# Rezoning Transportation Analysis

Petition Number: 2022-174

| Date    | Description       |
|---------|-------------------|
| 2-22-23 | First Review (IW) |

**SITE PLAN** SCALE 1:20

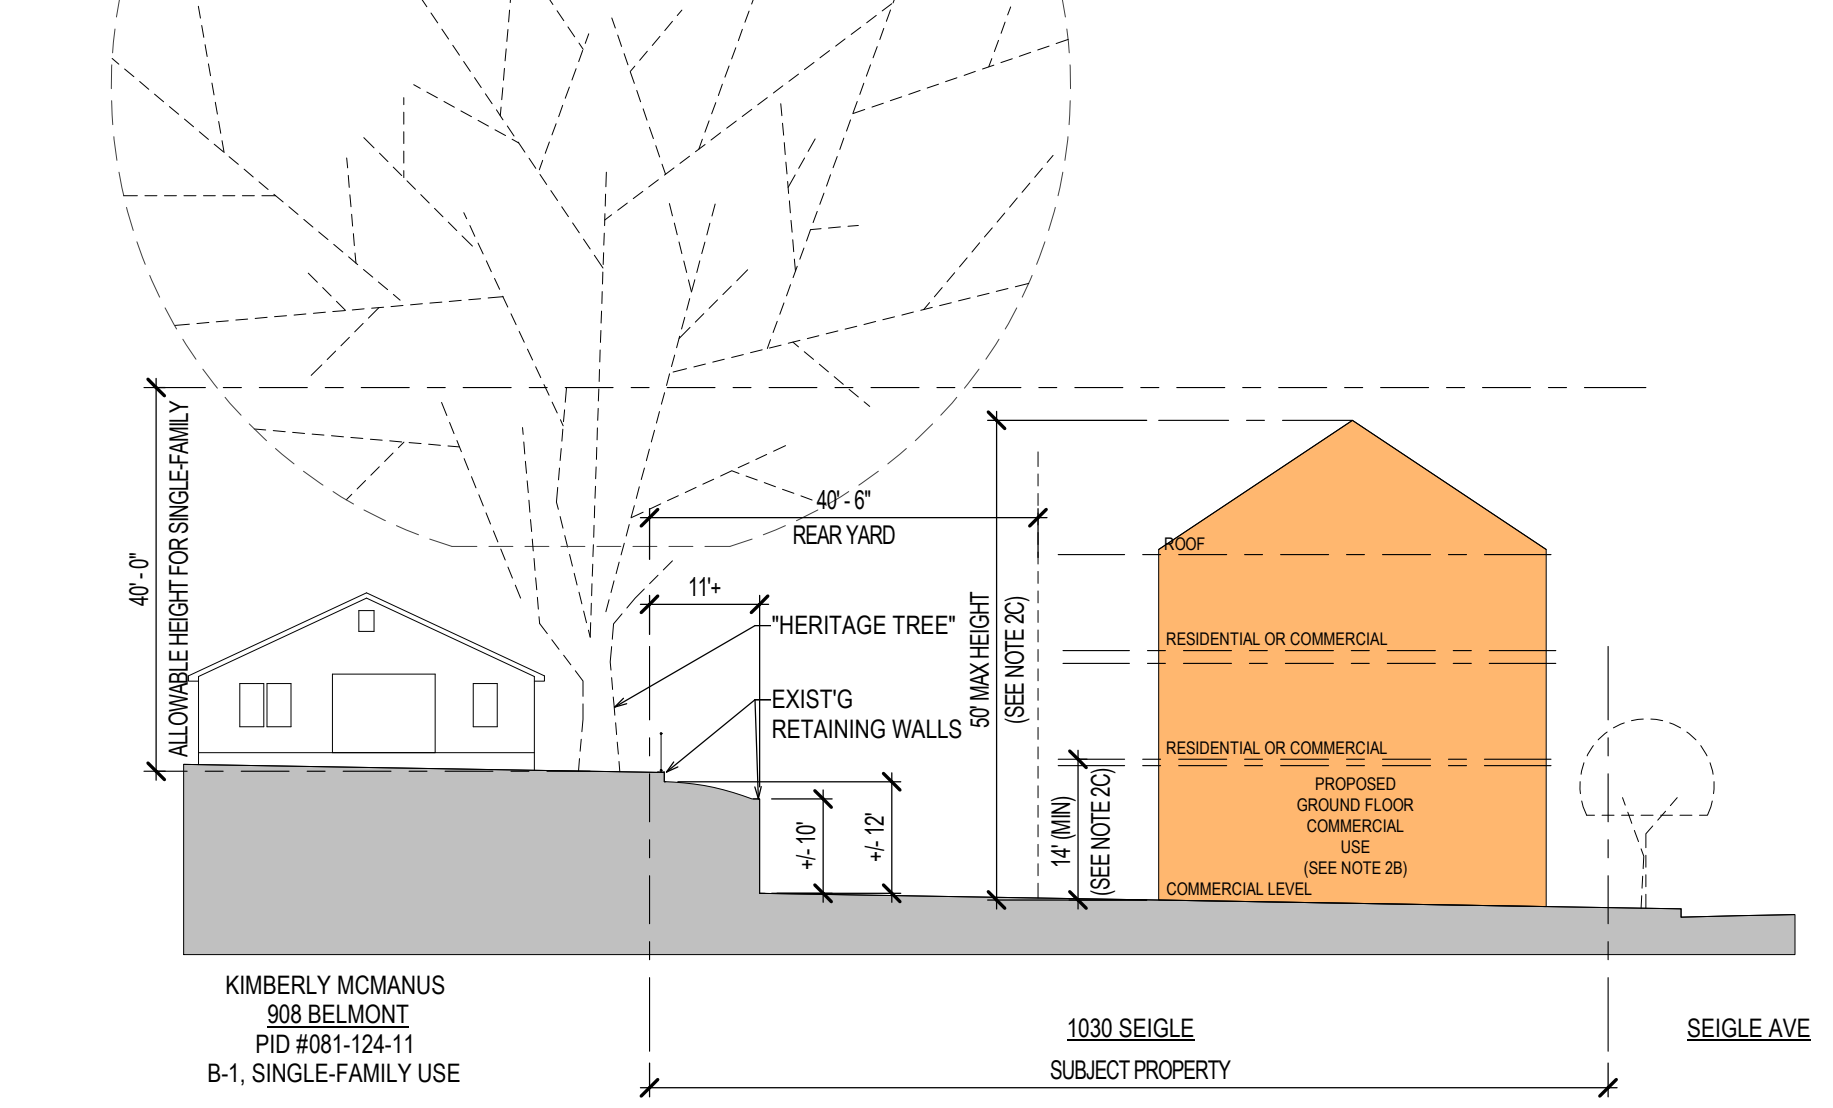
- a. **Belmont Avenue:** Location of curb and gutter to be moved to 15 feet from roadway centerline to accommodate the Charlotte Streets Map with a roadway typical section of Local Collector CLDSM U-07.
- b. **Seigle Avenue:** Location of curb and gutter to be moved to 18.5 feet from roadway centerline to accommodate the Charlotte Streets Map.

Label and dimension the curb and gutter from the centerline for each road on the site plan.

3. Revise site plan and conditional note(s) to commit to dedicate 51 feet of right-of-way from the Belmont Avenue centerline. The site plan shall label and dimension the right-of-way from the road centerline.

4. Revise site plan and conditional note(s) to commit to dedicate 36 feet of right-of-way from the Seigle Avenue centerline. The site plan shall label and dimension the right-of-way from the road centerline.

5. Revise site plan and conditional note(s) to commit to construct an 8-foot planting strip, and 8-foot sidewalk on Seigle Avenue per Chapter 19 and to support the council adopted Charlotte Streets map. The site plan shall label and dimension both items from the back of curb and gutter or edge of pavement.
